**Consultation Response from KC,
Lead Local Flood Authority**

2023/93726 40, Underbank End Road, Holmfirth, HD9 1ES

**Demolition of conservatory, erection of two storey side extension and detached garage,
formation of parking deck and alterations to garden (within a Conservation Area)**

Date Responded: 6th March 2024

Site Plan as Proposed

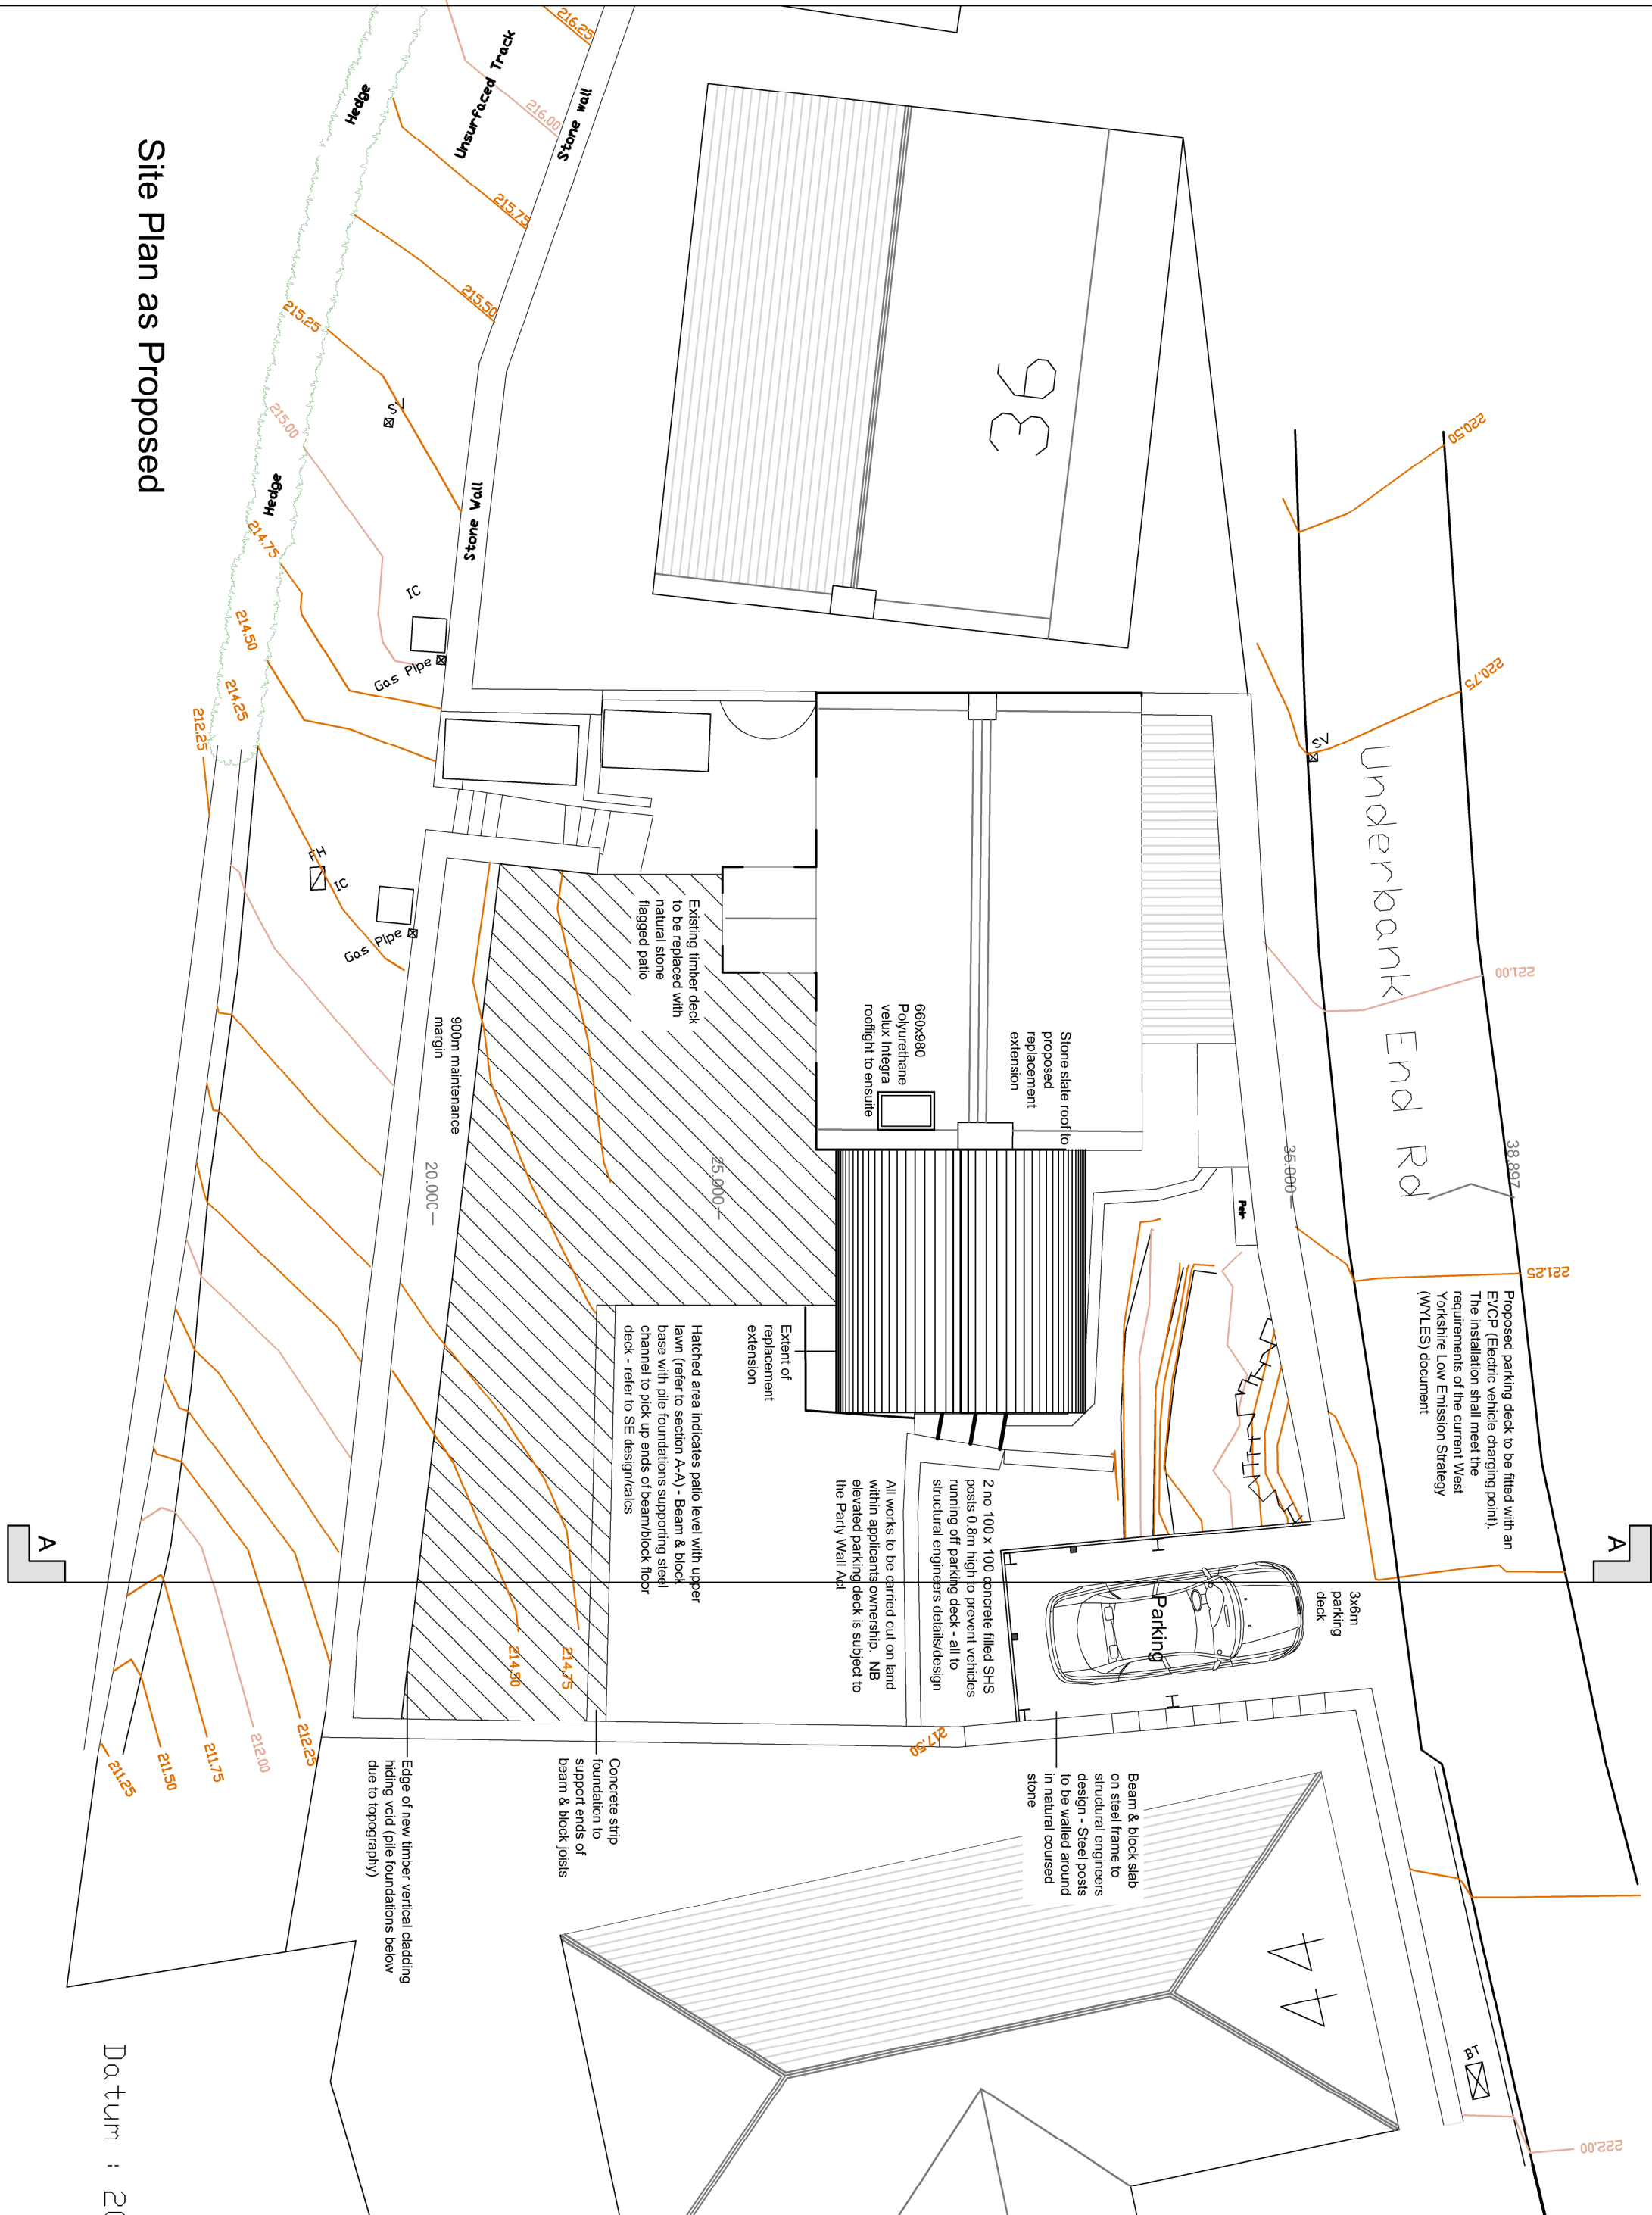
Kirklees Flood Management & Drainage OBJECTS to this application as the garage curtilage appears to correspond to the indicative location of a culverted watercourse.

FURTHER INFORMATION is required from the Applicant to determine the actual location of the culvert, its size, depth, and condition, in order to determine whether it is safe to proceed or whether alterations are required due to stand off requirements.
